Development Facilitation Team (DFT) – Review Comments

Project No: PR-2022-006568 Date: 2/26/2025 Agenda Item: #7 Zone Atlas Page: C-20

Request: Final Plat of 2 Lots into 8 Lots with Right-of-Way Dedication.

Project Name: VALENTINO ESTATES

PLAT
VALENTINO ESTATES
 (A REPLAT OF LOTS 4 & 5,
 BLOCK 16, TRACT 3, UNIT 3,
 NORTH ALBUQUERQUE ACRES)
 WITHIN THE
 ELENA GALLEGOS GRANT
 PROJECTED SECTION 17
 TOWNSHIP 11 NORTH, RANGE 4 EAST, N.M.P.M.
 CITY OF ALBUQUERQUE,
 BERNALILLO COUNTY, NEW MEXICO
 JUNE, 2023

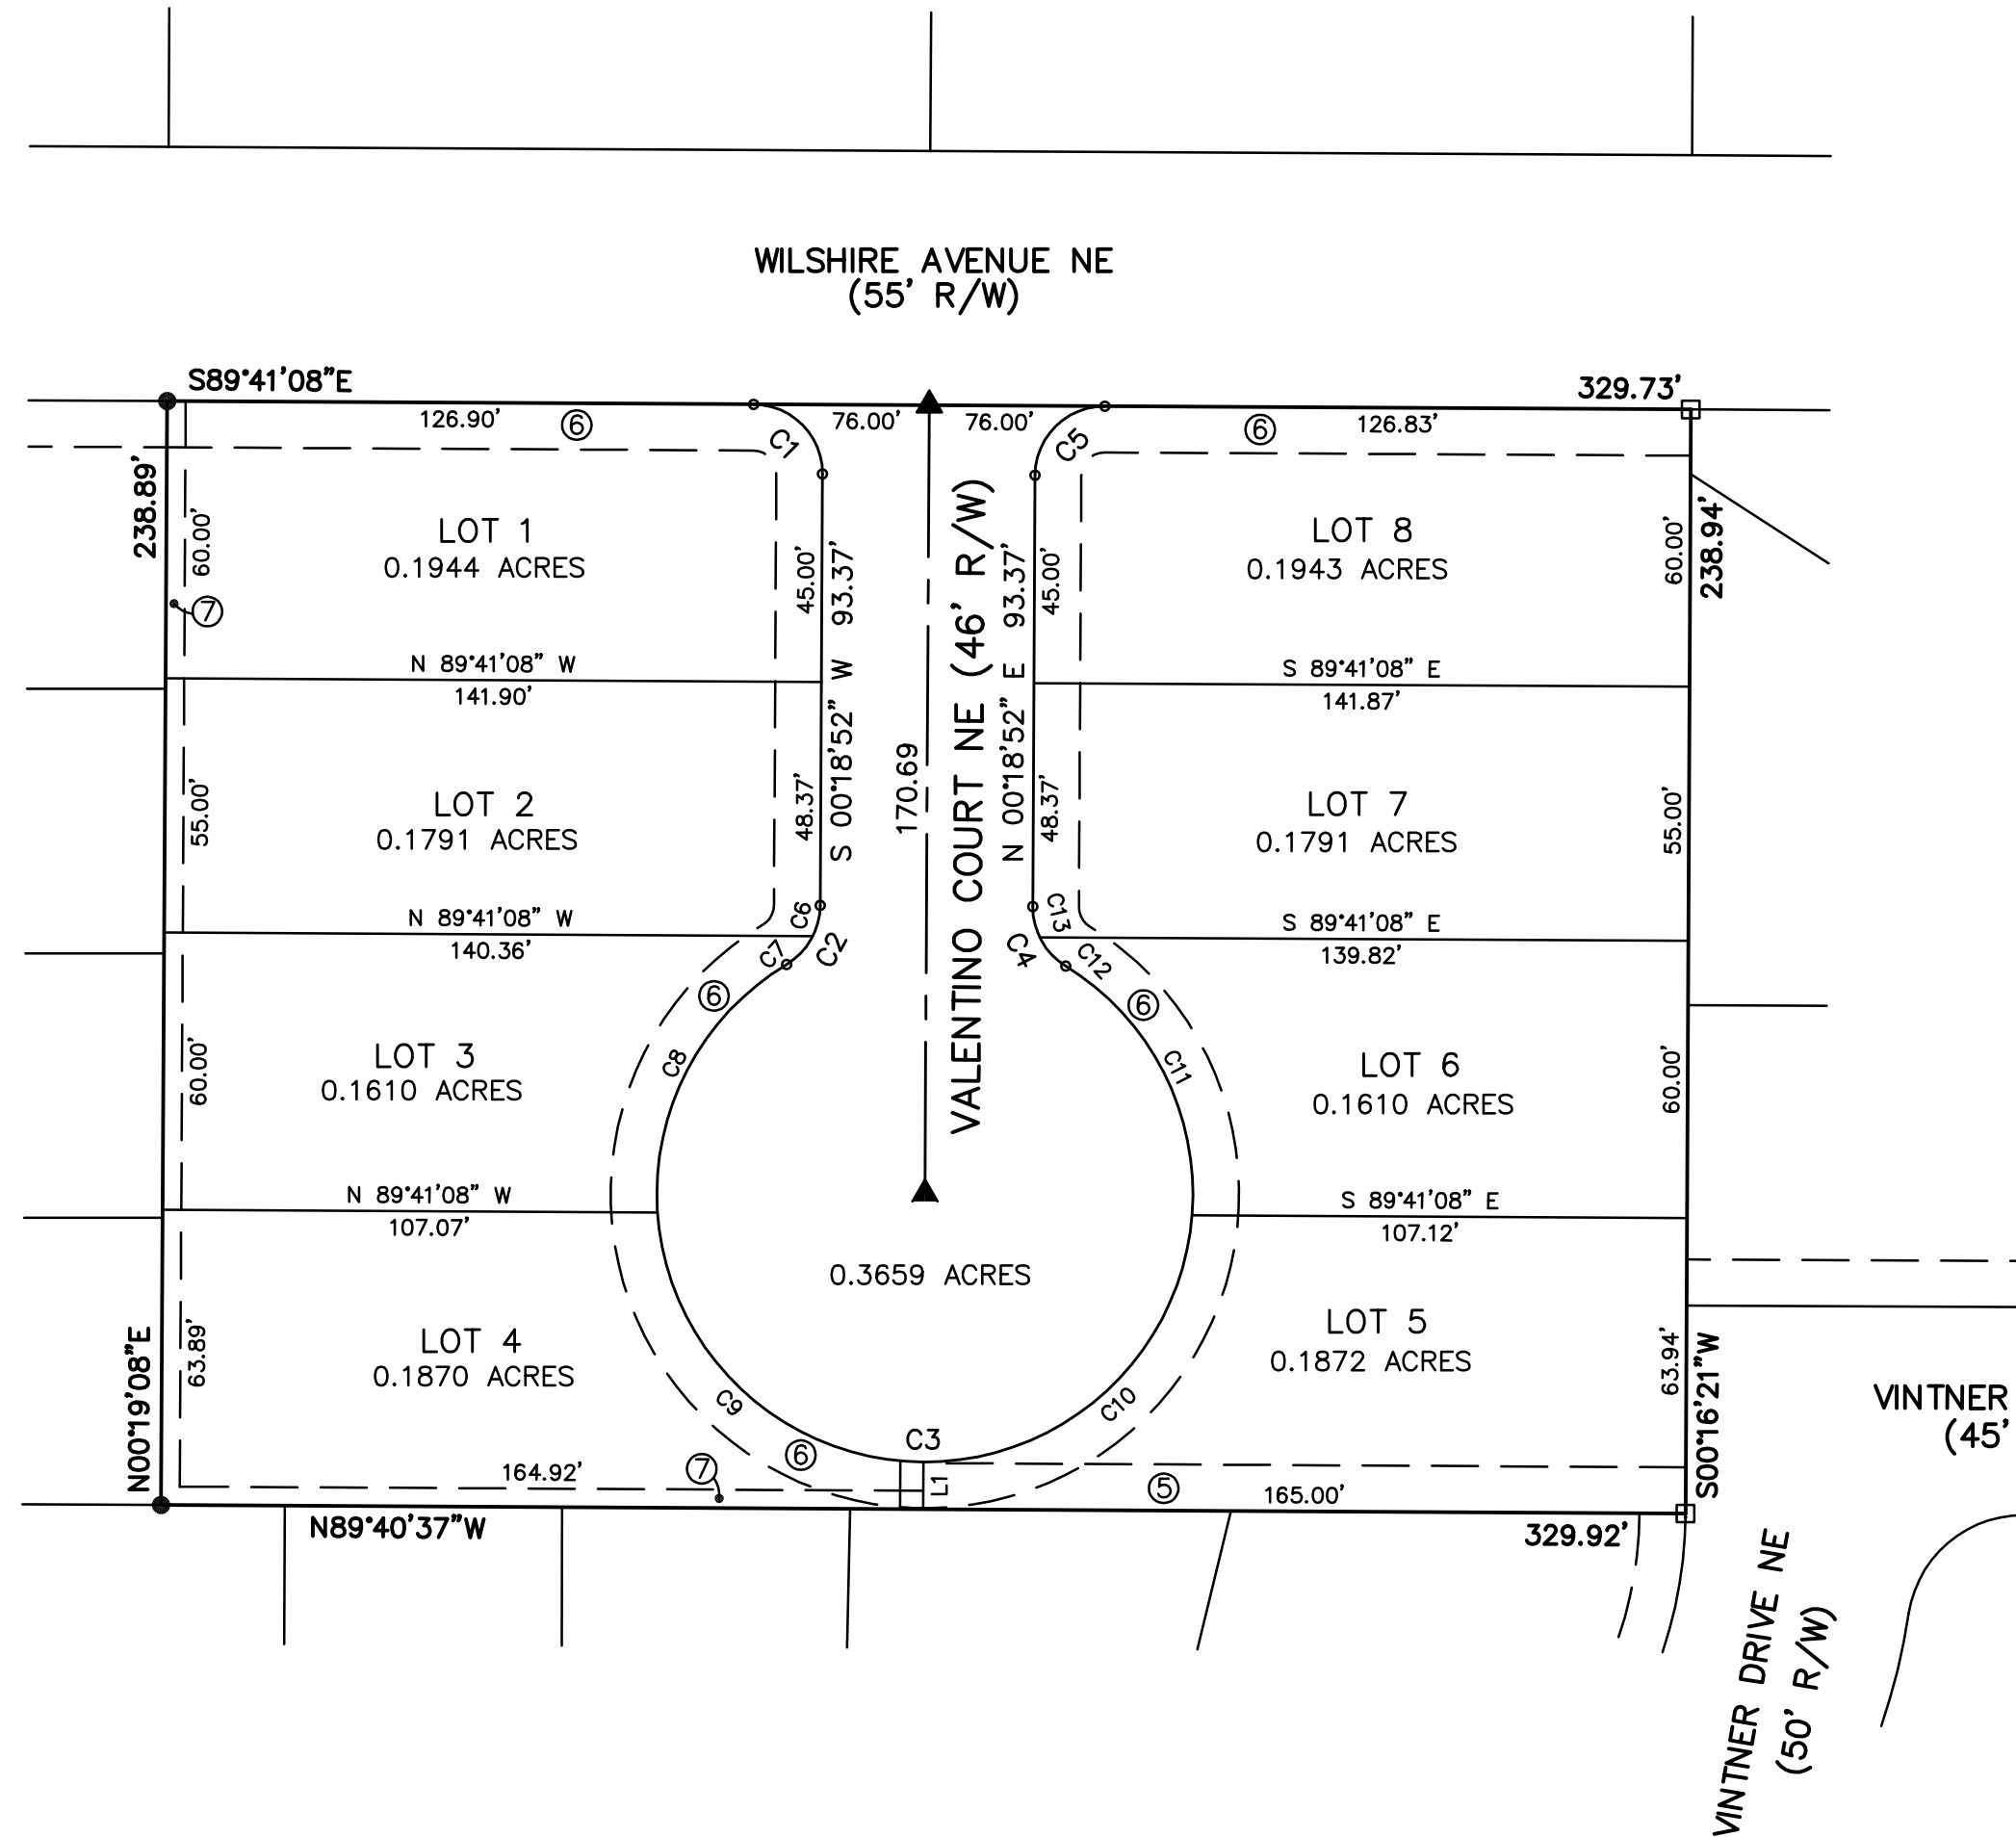
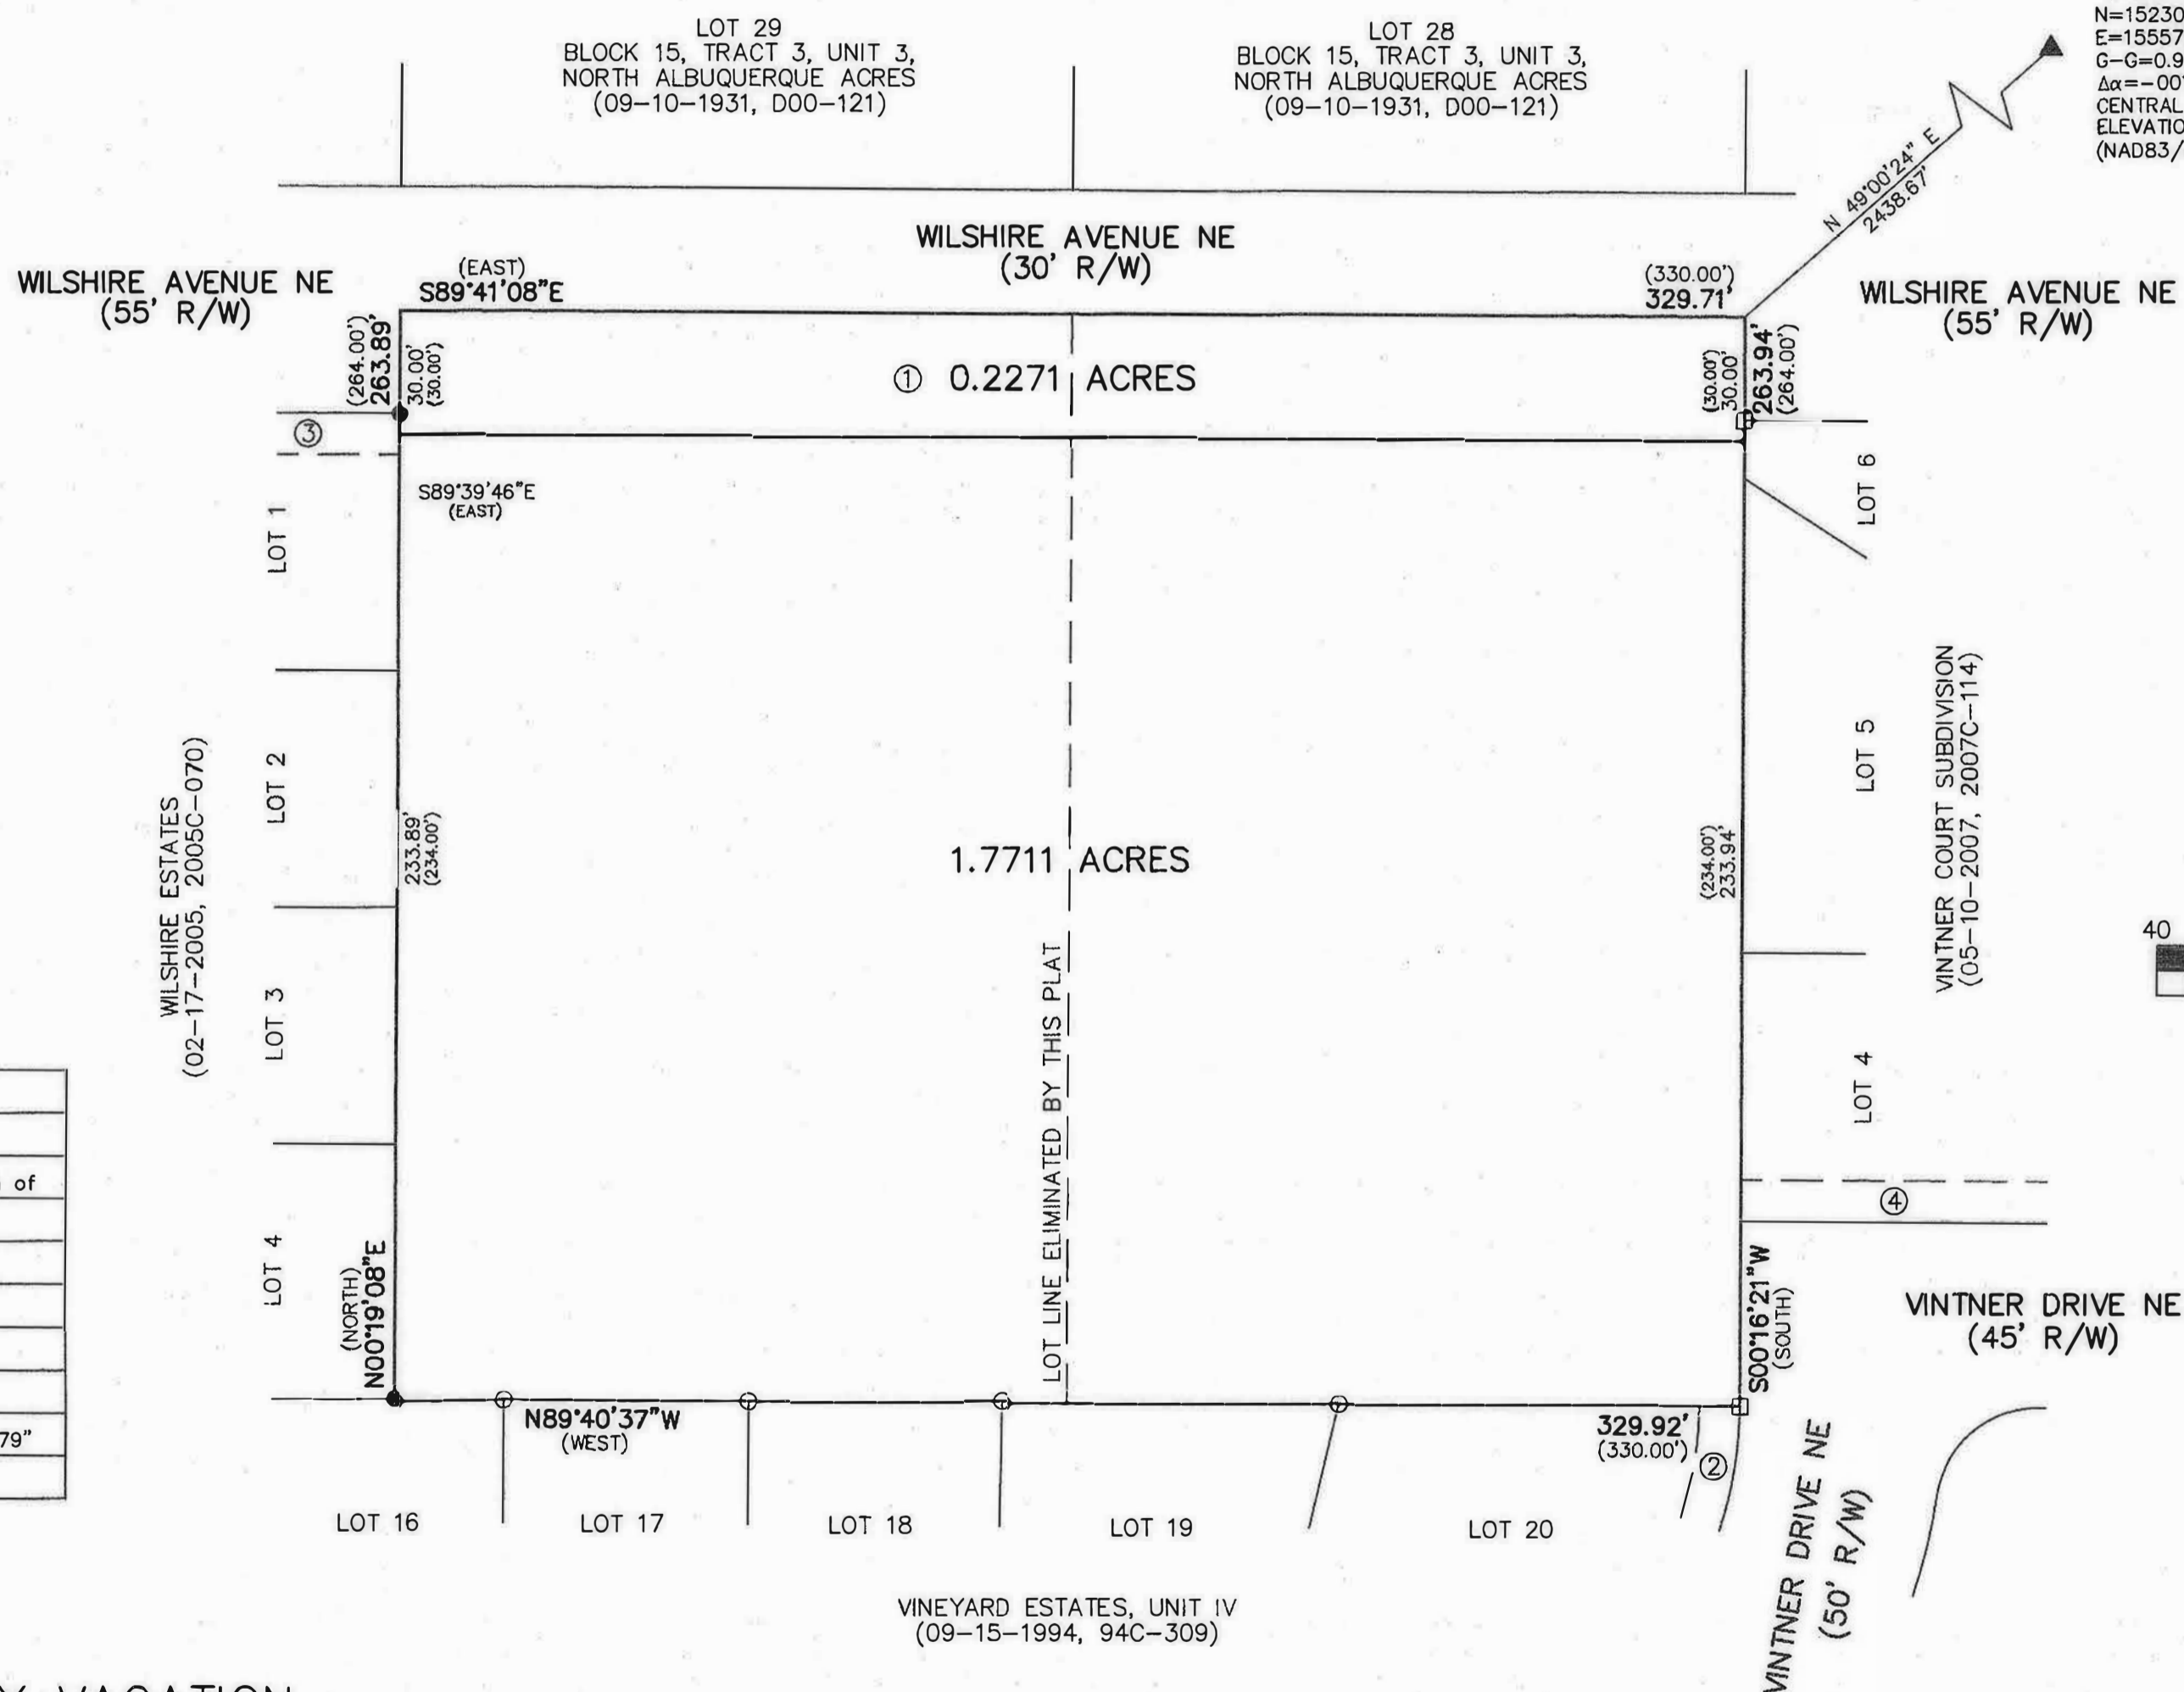
- The application number on the Plat must be corrected to SD-2025-00007.
- Proof of approval of the DXF file from AGIS must be provided.
- ~~The recorded IIA provided in the application submittal for this request is for another Final Plat, PR-2019-003169 / SD-2024-00151, which was approved by the DHO on October 30th, 2024. Before this request can be approved, the correct recorded IIA for this request must be submitted.~~
